14 December 2022

RE: RtS for SSD-10272349 Yiribana Logistics Estate

Thank you for notifying Sydney Water of RtS for SSD-10272349 Yiribana Logistics Estate proposed by The GPT Group (GPT). The development consists of a Concept Development application for an industrial estate consisting of five warehouses including approximately 151,125m² of industrial, warehouse and distribution centre floor space and 6,735m² of ancillary office floor space.

**POST DEVELOPMENT
STORMWATER CATCHMENT PLAN**
SCALE 1:2000

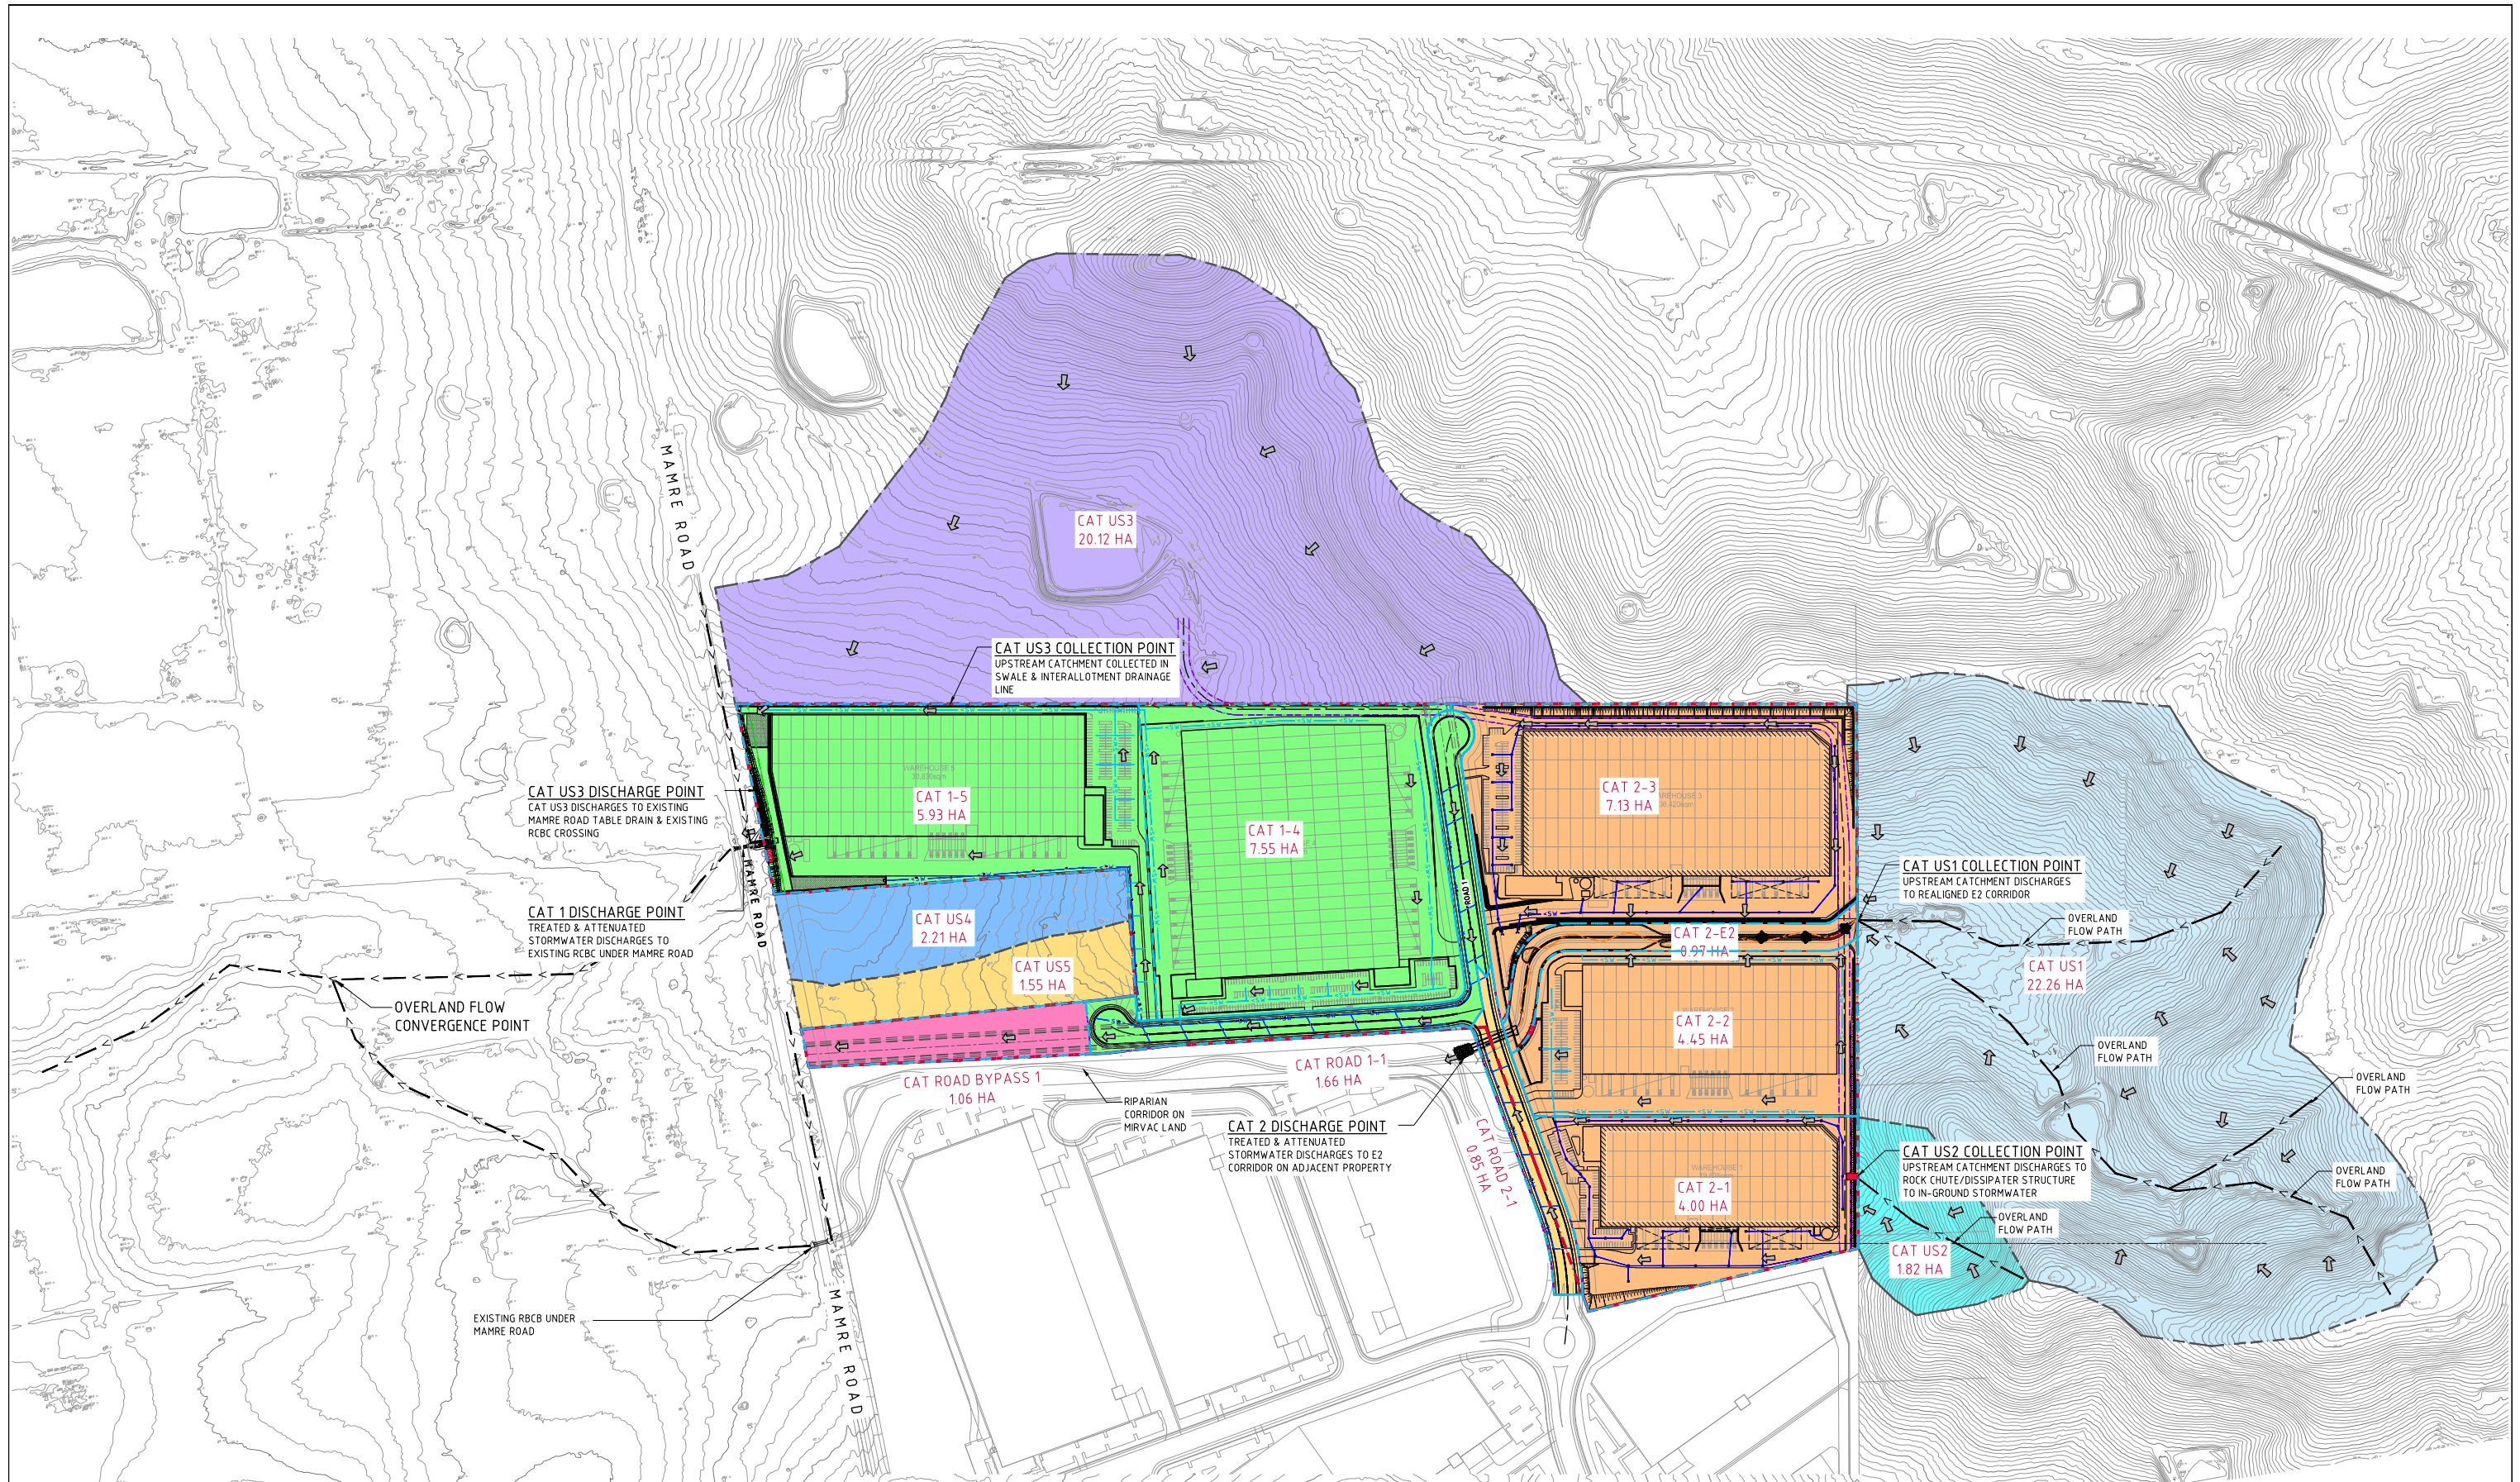
No catchment/WSUD Plan or table has been included in the reporting. A plan and table must be provided displaying:

- all natural and proposed developed catchments (including those upstream of the Yiribana estate development boundary) and land use splits (including areas/% impervious)
- drainage locations and any proposed flow diversions
- temporary WSUD systems
- proposed irrigation areas for temporary tanks and ponds

LONGITUDINAL SECTION - GPT E2 CHANNEL

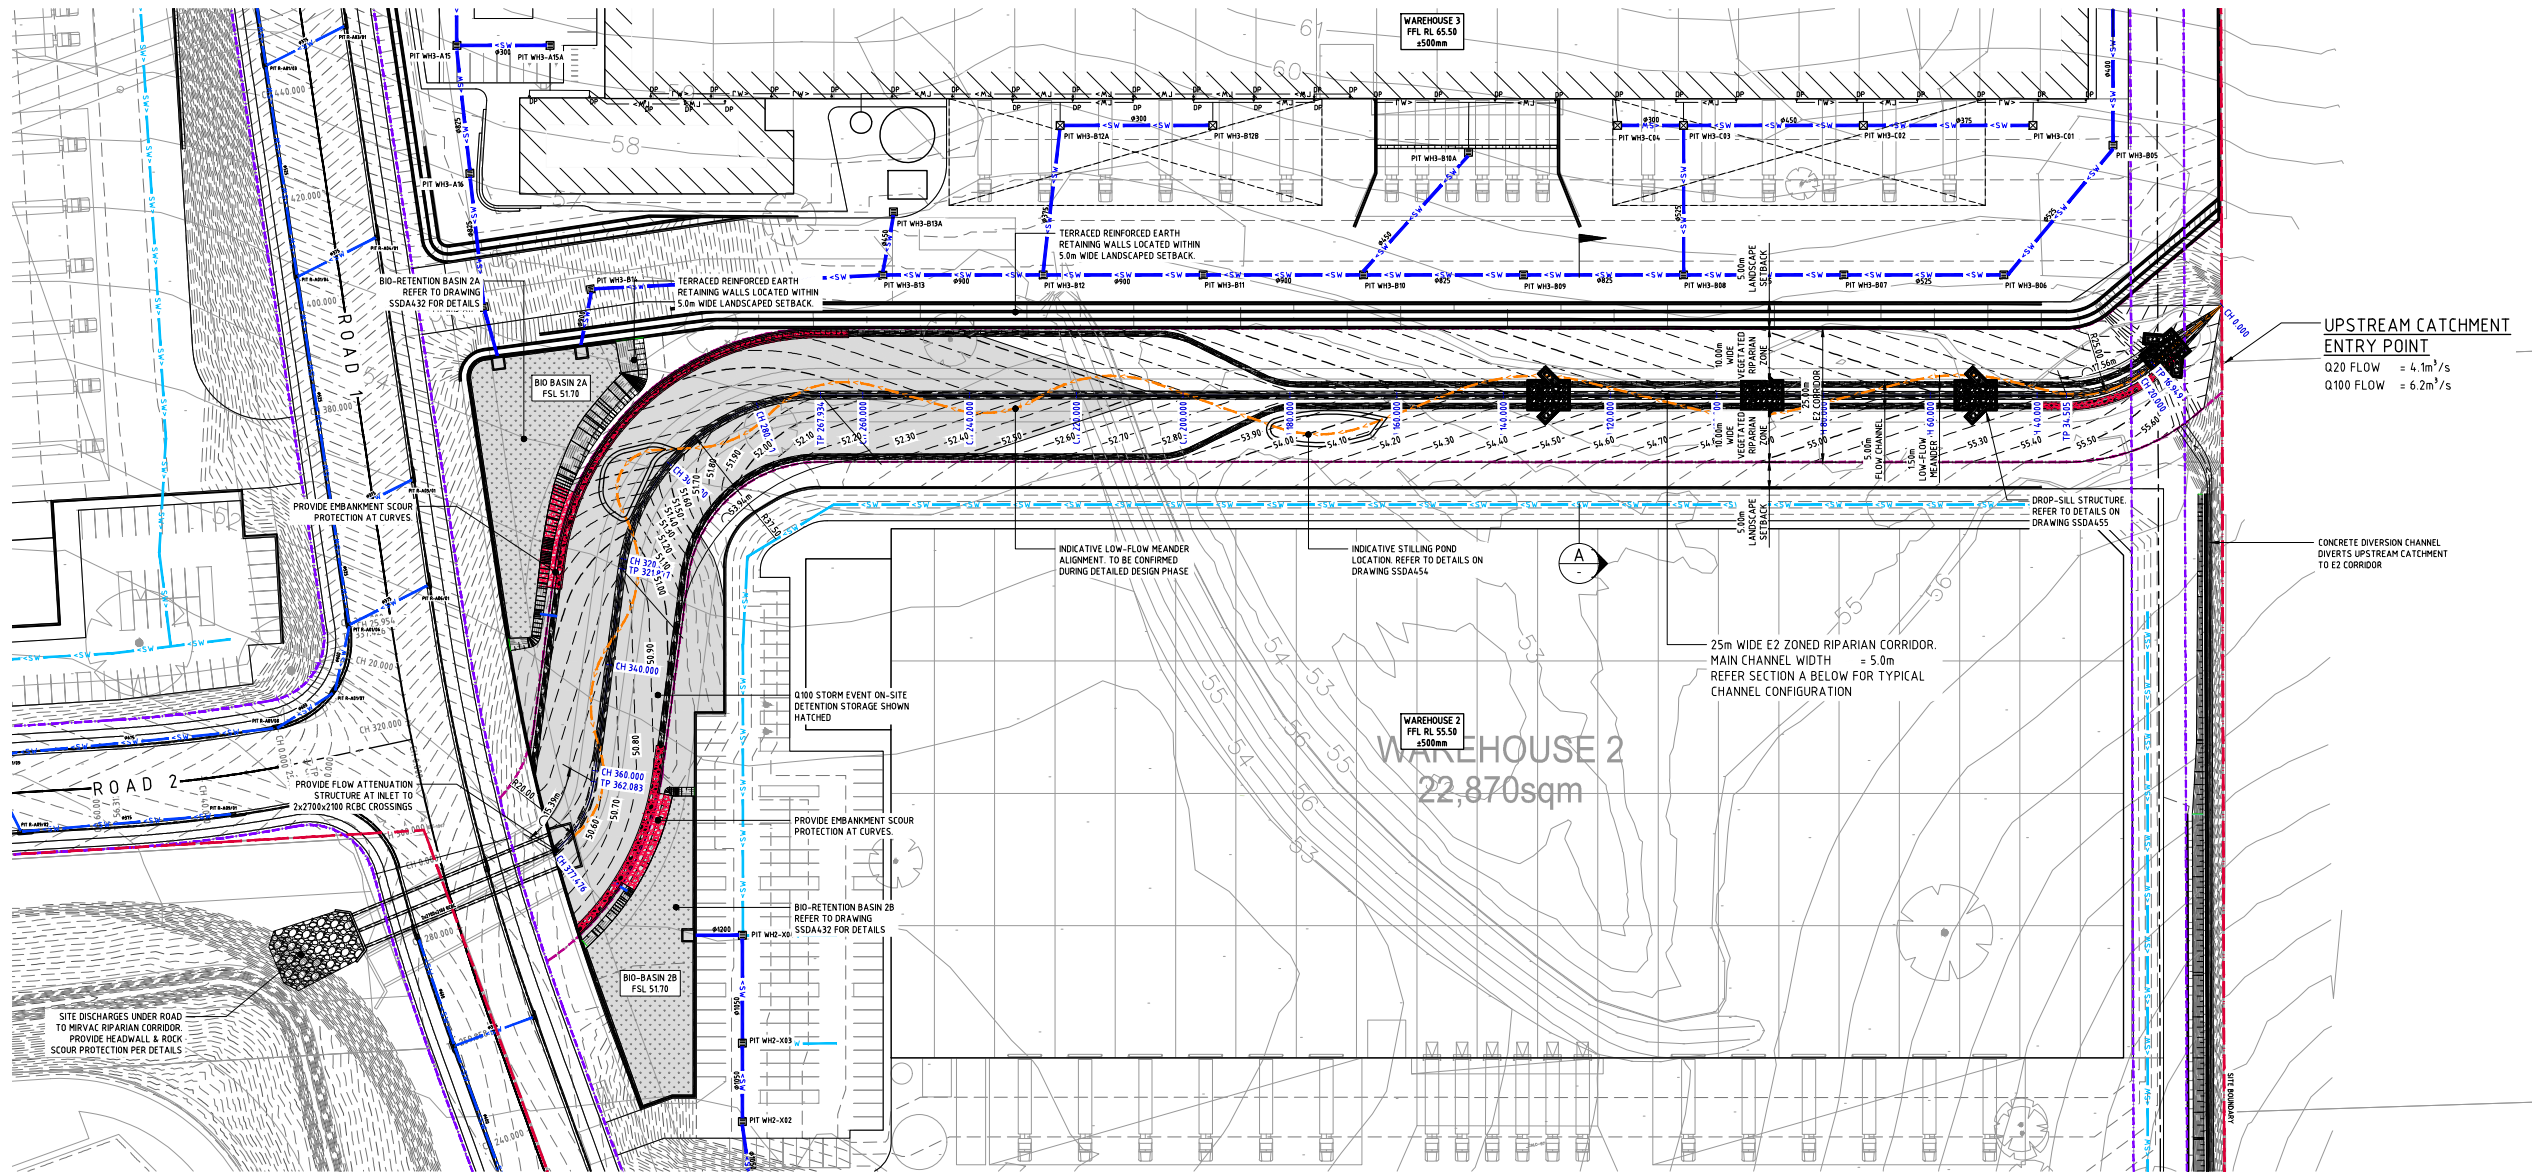
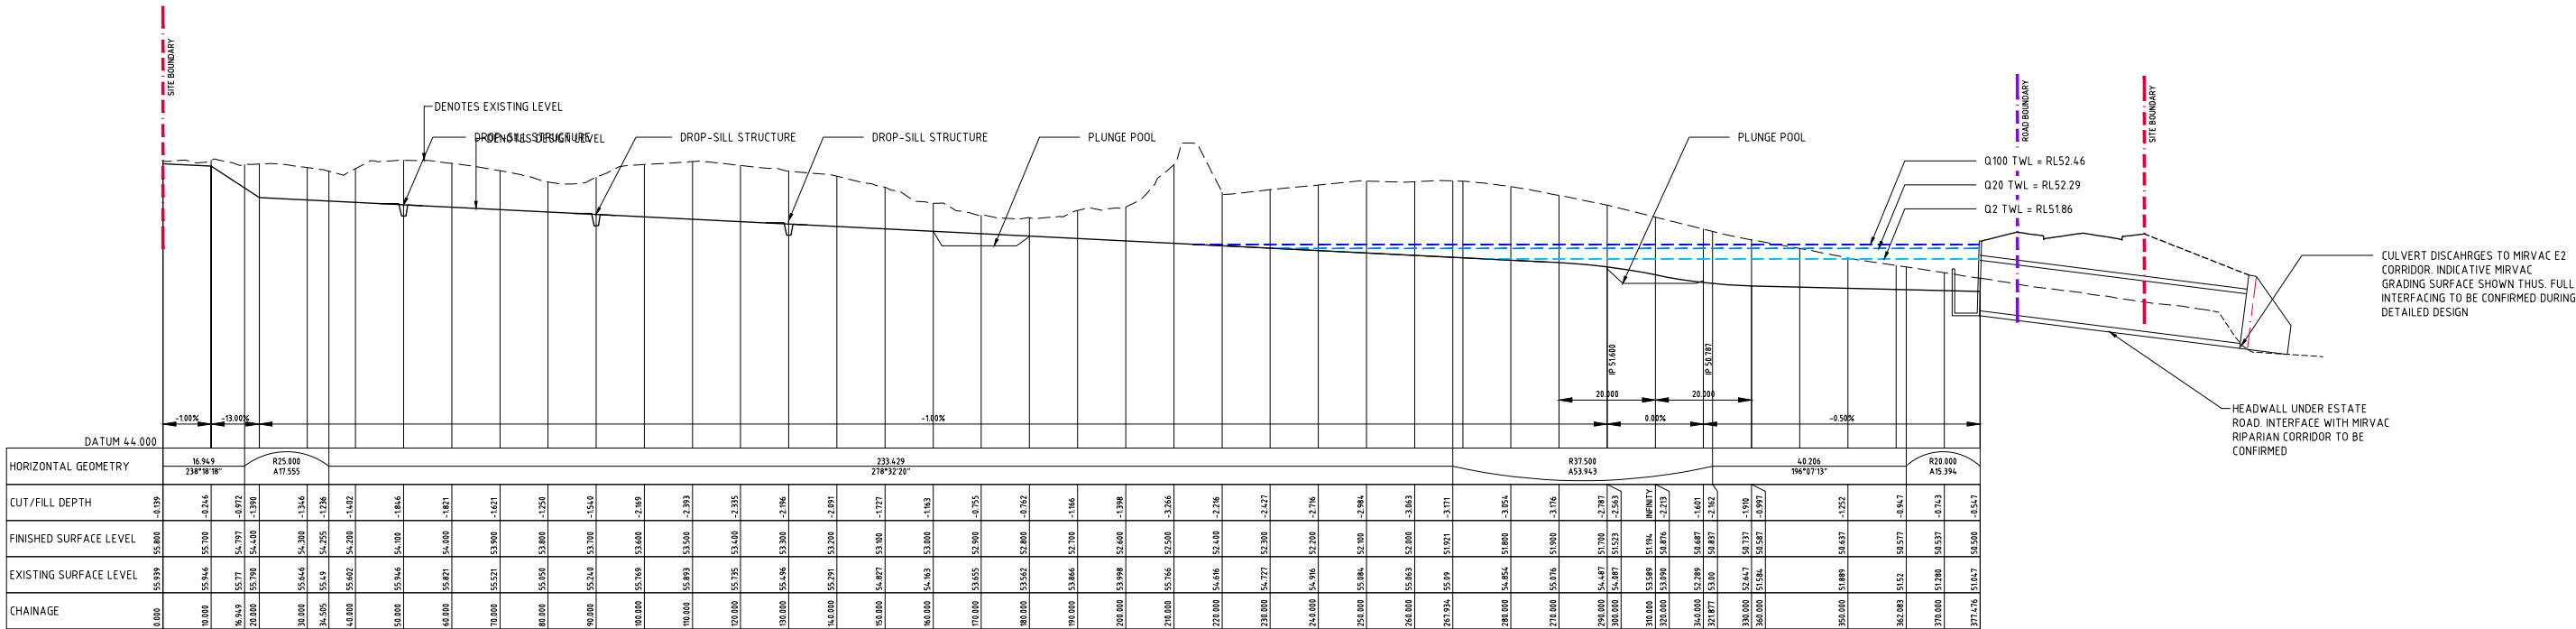
- drawings have indicated a 5m wide channel with 3.8m base to convey low flows.
 - The low flow channel must be sized to contain the 4EY.
 - Batter slopes should be between 1:4-1:6 wherever feasible, localised steepening of banks with appropriate surface treatment to protect from shear stress and velocity will be accepted to facilitate low flow channel base meander.

- Sydney Water requires a compound waterway form wherever possible to assist in provision of low flow channel sinuosity.
4. The longitudinal grading of the trunk drainage is significantly greater than 0.8% as such details of shear force calculations are required to be provided for low flows, 1% and 10% AEP flows and demonstration of appropriate surface treatment to protect from erosion. This is particularly important at the entry and exit of the major bends.
